From: Kerrie Simpkins [REDACTED]
Sent: 10 May 2021 21:37
To: Finlay Gardner <Finlay.Gardner@arun.gov.uk>; [REDACTED]
Cc: Lee Simpkins [REDACTED]
Subject: Planning Application BN/43/21/HH

We formally object to planning application BN/43/21/HH that seeks permission for an extension to the rear and elevation of No. 25 Skylark Way's existing garage.

Proposed East Elevation

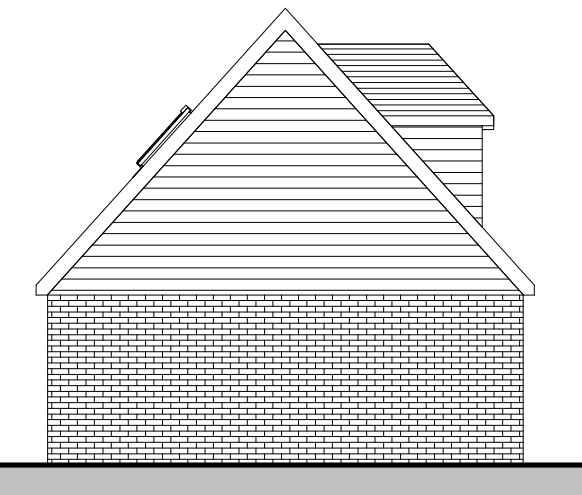
back towards our house it will create loss of daylight and will also feel imposing and intrusive on our enjoyment of our detached property. We had purchased this particular plot due to the positioning of the house and it's distance to other properties.

Proposed North Elevation

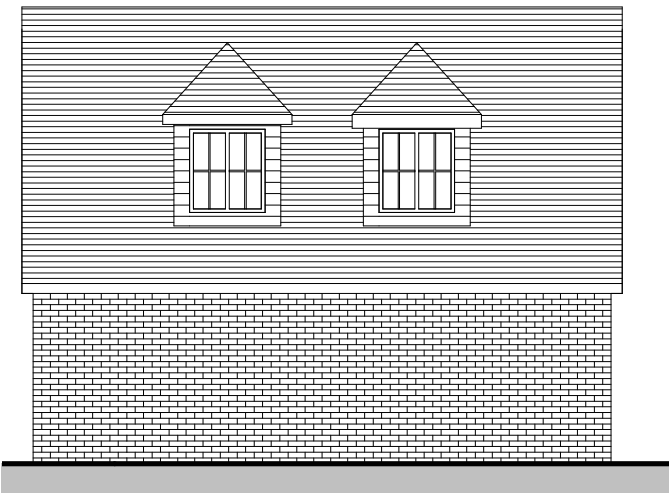
4. We further object against the installation of dormer windows on the North Elevation due to invasion of privacy. On the West Elevation of our property our windows are for the use of two of our bathrooms. This would mean the adjacent property will be able to look down into our toilet or across to our shower. This potential invasion of privacy cannot be underestimated. We enjoy where we live and the position of our house and where it sits, as it is, in relation to our neighbours. We would feel extremely uncomfortable using these rooms for their intended purpose. The dormer windows are also not in keeping with the character of our street. For example the size, appearance of other garages within the development. We also believe this will then create a 'free for all' for other dwellings to propose further extensions to their properties within the development. We would like to suggest the use of Velux windows instead for both North and South Elevations.
